REVIEW COMMENTS						
Project:		NM383.02 - Anderson Heights TIS Update			PDE:	
Review:					Reviewer:	
Date:		10/15/2024			Margaret Haynes (NMDOT)	
#	PAGE	SECTION	COMMENT	AUTHOR	STATUS	RESPONSE
1	ALL	ALL	Acceptable turn lanes are those that include queue plus deceleration, if it only includes the queue length, then it is not SAMM compliant.	MH	Noted	
2	ALL	ALL	Please include recommendations from the previous report at all other study intersections.	MH	Agree	Added recommendations to report.
3	4	Adjacent Developments	Correct development name is Ceja Vista	MH	Agree	Corrected development name.
4	6	Capacity and Queueing Analysis	Can you explain what is meant when a Through lane does not accommodate 95th queue lengths?	MH	Agree	95th percentile queue lengths calculated by HCS exceed measured turn lane lengths.
5	7	Capacity and Queueing Analysis	Please provide existing turn lane storage by lengths including taper.	MH	Agree	Added to tables

Figure 10: Coors Blvd and Rio Bravo Blvd (NM 500) HFIN Map

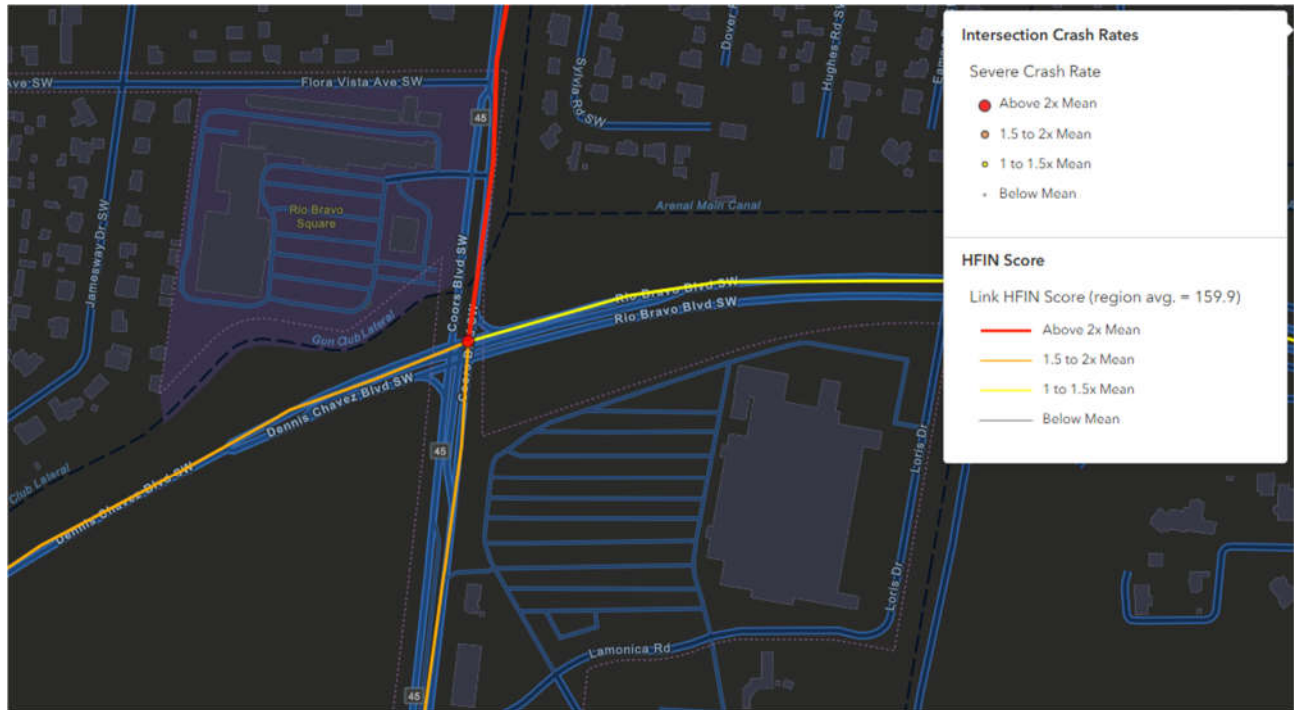
6	8	Crash Summary	Please include MRCOG's HFIN map as a part of your Crash Summary.	MH	Agree	Updated to include an image of the HFIN
7	9	Crash Summary	Can you explain Crash Type: Pedestrian - 6	MH	Agree	Corrected number of ped involved crashes. 6 drivers reported "Pedestrian" for a total of 3 crashes.
8	11	Conclusions and Recommendations	Please maximize the NBL at NM 500 and NM 45, by limiting the SBL deceleration lane at NM 45/Las LaMonica to 400-feet including taper. There is about 940 feet of storage total.	MH	Agree	Updated to include recommendation
